Ribble Valley Borough Council

App no: 25.0100

Address: Land at The Eagle at Barrow Clitheroe Road Whalley BB7 9AQ

Further to the original comments dated 24th March 2025, the submitted document 'Stantec Technical Note dated 18th August 2025' has been reviewed and the following comments are made.

proposed site plan
scale - 1:250@ A1 / 1:500 @ A3

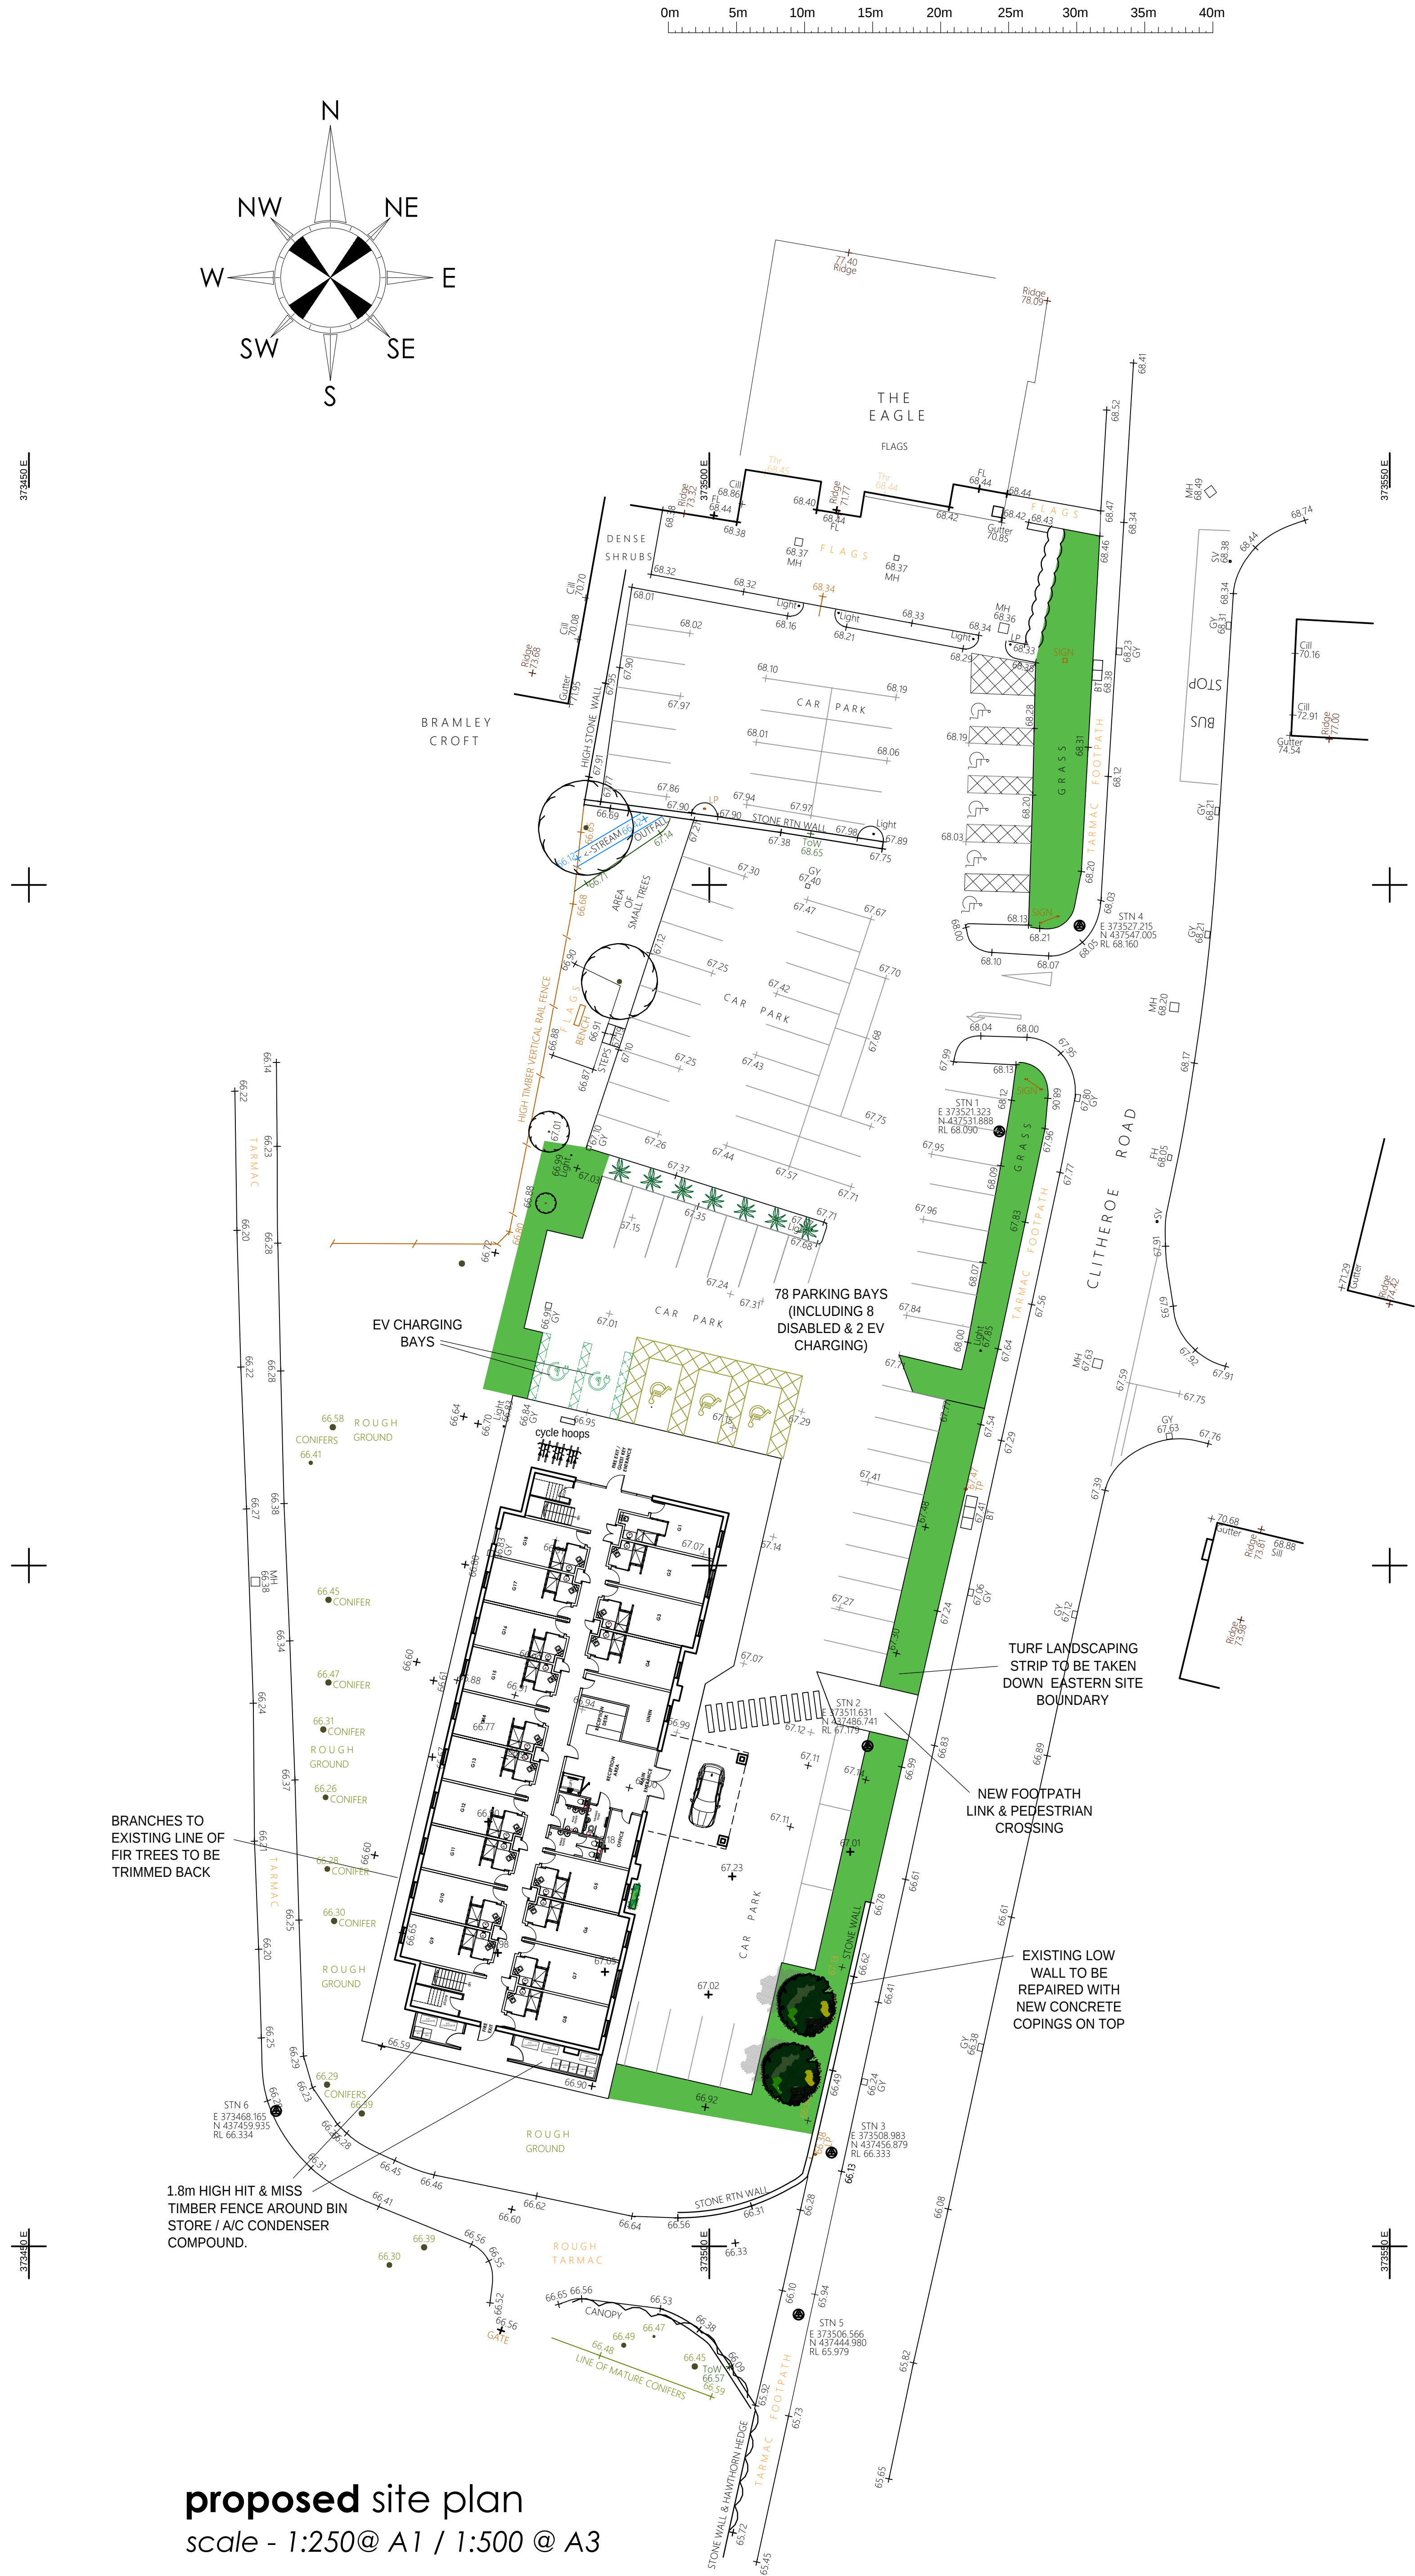
Measures for cyclists to enter the Hotel via the new pedestrian access on Clitheroe Road with a dropped crossing point, signage and lining on Clitheroe Road are agreeable.

The provision of high quality secure and covered cycle parking is not discussed in the Note. Cycle hoops are proposed on the original layout.

However, it is anticipated that the recorded speeds are likely to be relevant for the site access with drivers maintaining this speed in the 30mph section, which would require splays of 2.4m by 57m to the southside and 58m to the northside.

As previously stated, subject to the provision of a traffic calming scheme of enhanced signing and lining and the provision of a central pedestrian refuge alongside the Hotel frontage we would anticipate that vehicle speeds would be reduced sufficiently to comply with the proposed visibility splay for a 30mph speed limit.

The Technical Note disputes the need for the traffic calming measures on Clitheroe Road. The Highway Authority would dispute that adequate visibility splays are provided at the site access.

There are currently 111 car parking spaces provided for the public house and this will be reduced to 78 spaces which is a loss of 33 spaces as a result of the proposal.

There are 8 disabled parking spaces and 2 electric vehicle charging spaces proposed, these should be 10% of the overall provision. There are 6 bicycle parking spaces (3 sheffield stands) proposed and these stands will need to be covered and secure and increased to 10% of the car parking provision. Motorcycle parking is required at 4% of the car parking provision. This can be dealt with by condition.
